# CITY OF PORTLAND BUILDING PERMIT

390 COMMERCIAL ST

PERMIT ID: 2012-65617

has permission to **install a supervised fire alarm system**

2nd Floor Fire Alarm System Legend

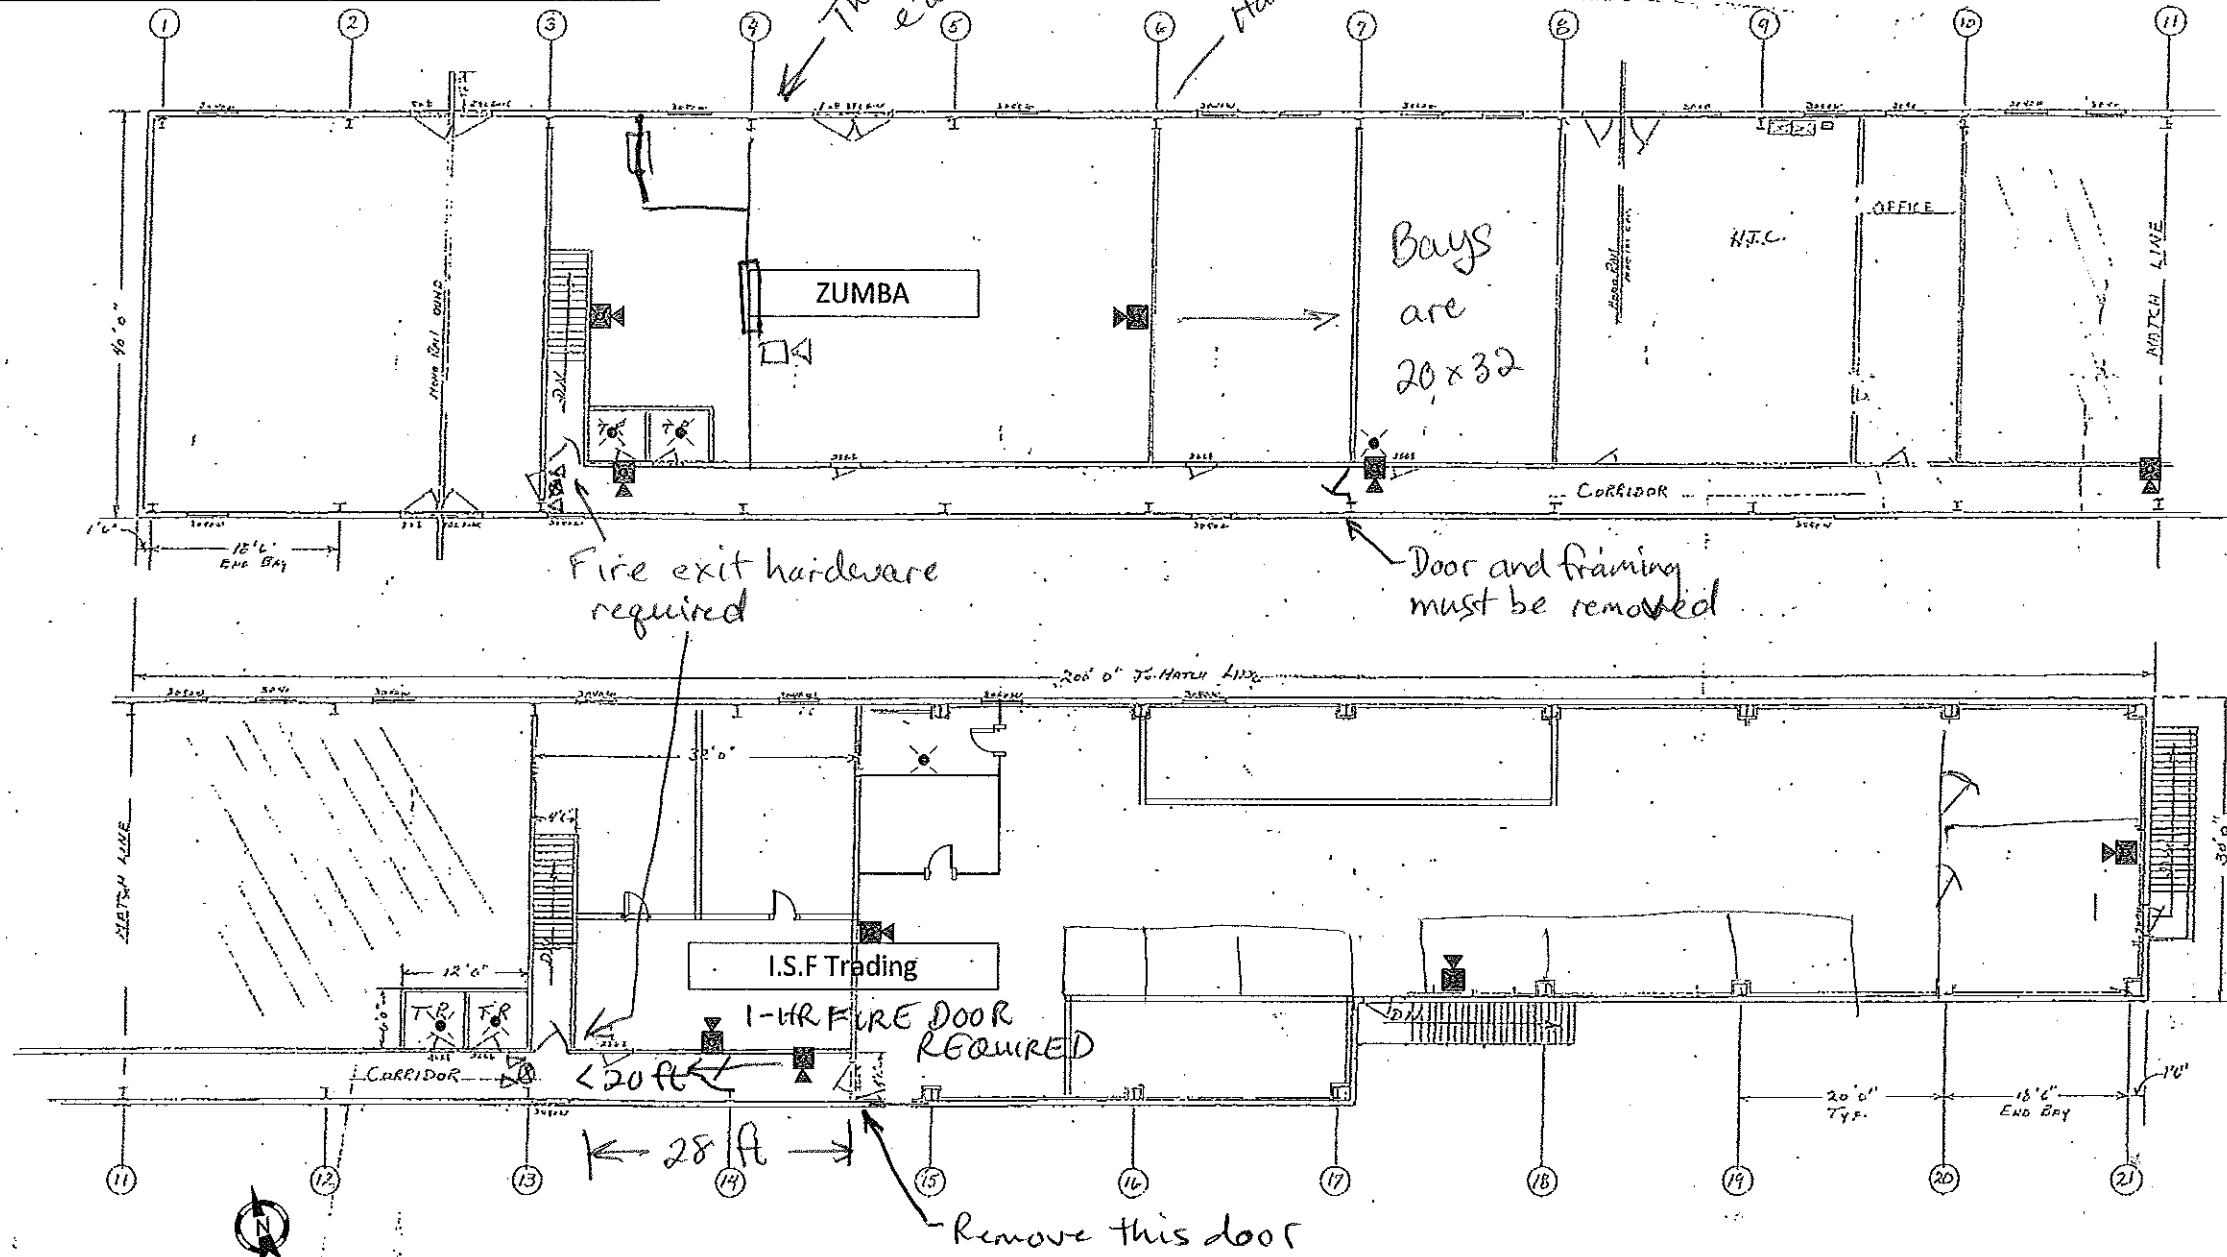
I'm going to approve a conditional fire alarm permit but beware the floor layout isn't as your floor plan showed. The South end of the second floor and a number of the spaces off the corridor have partitioned rooms within them. Also the left end of the studio space as you enter is partitioned off and the wall the plan shows in the studio has been removed so it's wide open. The dimension of the open studio space is approximately 60 x 32. 60 candela strobes at each end should do the open space but you'll still need strobes in the adjacent partitioned space and adjust for the partitioned spaces in the rest of the floor.

I want to see the fire alarm control panel get installed in the in the cross corridor on the South side of the North stair by the bathrooms. It's about the only space suitable for it. Be careful with placement of the FACP smoke detector. If they put FIRE ALARM signage on the door from the stair into the corridor we'll allow them to do away with the annunciator given the panel's proximity. Install an exterior strobe over the Knox box on the latch side of the door.

The owner has submitted conflicting floor plans. As you can see from the attached plans that was submitted with the change of use permit the corridor appears to continue to the other end of the second floor with rooms

to each side and neither plan shows the correct configuration of the proposed Zumba space according to a discussion Jeanie and I had with the engineer the owner hired to provide a code analysis. I'm not sure which plan is correct but in any case neither are to scale so they'll need to have scalable architectural quality plans drawn up for the building and you can add you fire alarm design to those.

Unfortunately the panel would be very difficult to install in the stairwell. Please notice the new location for of the FACP, smoke and document box. It's located next to an existing electrical panel; this area is dry according to the owner.

The spaces that don't have notification devices are unoccupied at this time; the intend would be to satisfy the notification requirements before occupancy.

The drawings are what was provided by the customer; I have inputted horizontal dimensions; if this does not suffice I will have to ask the owner to have scaled drawings produced.

2nd Floor Fire Alarm System Legend

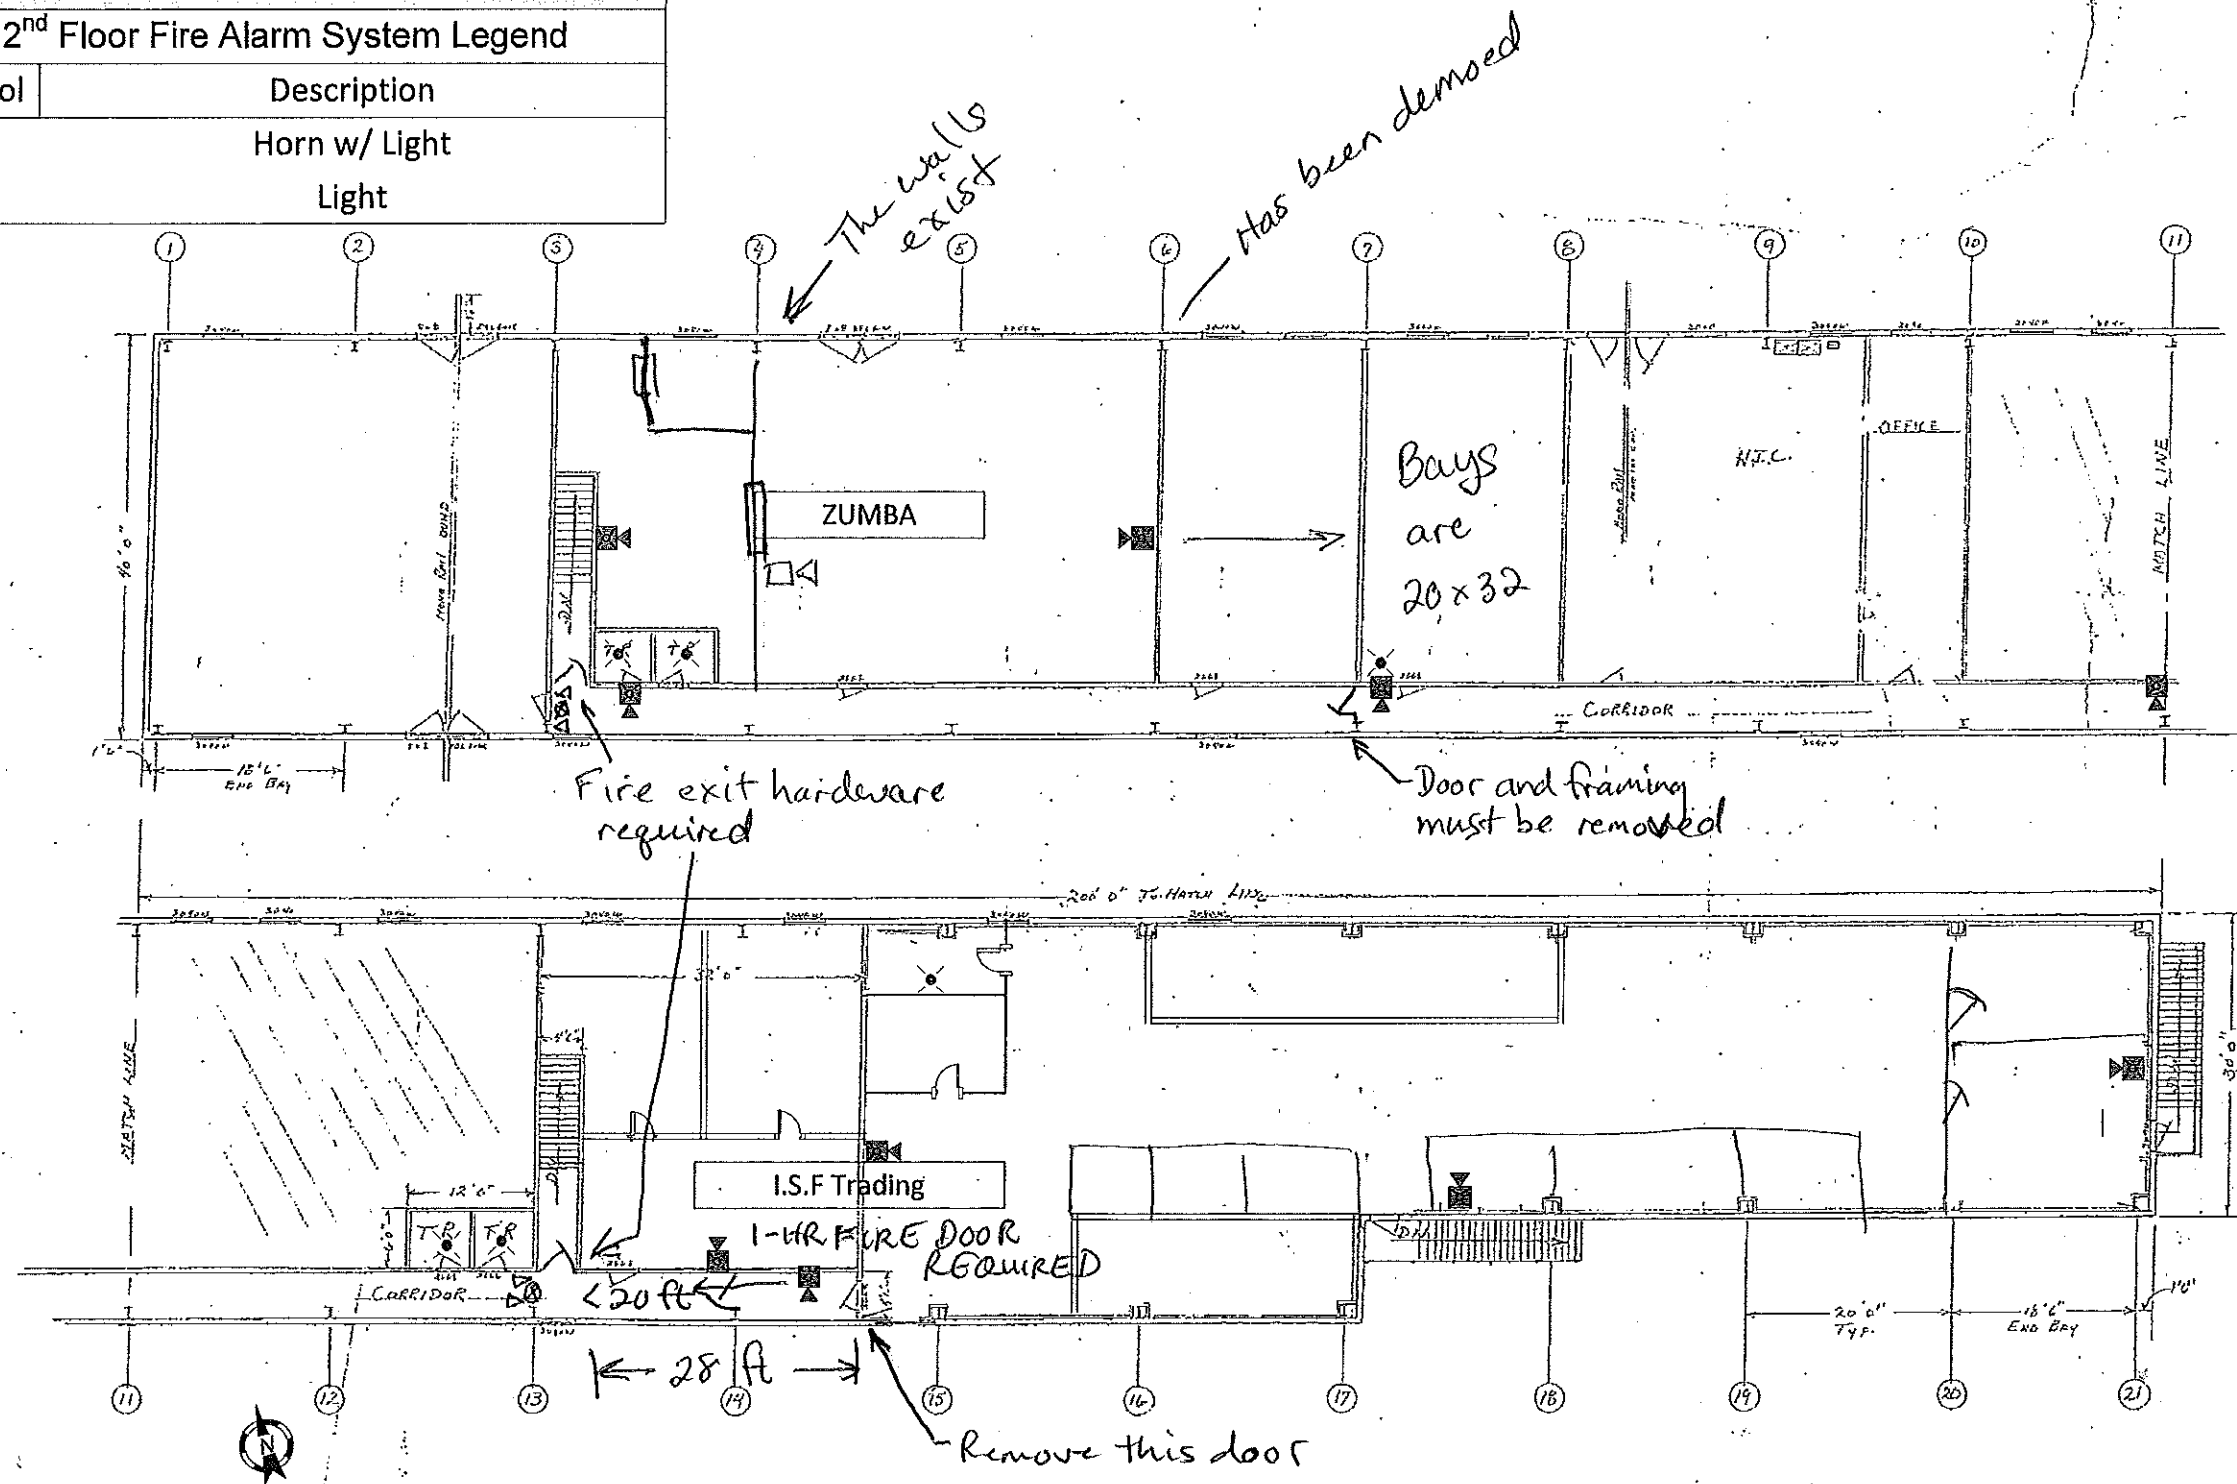
1. Is the first floor fish processing suitable for interior horn/strobes or is it a damp location?
2. The first floor plan shows the FACP and smoke detector open to the rest of the space. Again I want to be sure the space is suitable for the panel and smoke detector installation or they're moved to a space that is suitable for them. One option would be to install them at the front door with the pull station in lieu of the annunciator.
3. There are no candella ratings indicated on any of the strobes so I have no way to verify the spacing. Please be sure to include the rating of the strobes on the floor plans and wiring diagrams. Also the plans need to be to scale for me to verify the spacing so that's required as well.
4. Are the spaces that don't have strobes private offices?

I've attached updated drawings with the candela ratings for the strobes and horn/strobes. All the 1<sup>st</sup> horn/strobes are ceiling mounted except in smaller rooms. The 1<sup>st</sup> ceilings are all suspended; the building owner verified that they do not wash down the ceiling. There is no manufacturer that produces a weatherproof ceiling mounted horn-strobe, I've researched this in the past. In similar applications we have found that ceiling mounted horn-strobes work better in this environment in lieu of wall mounted weatherproof horn-strobes.
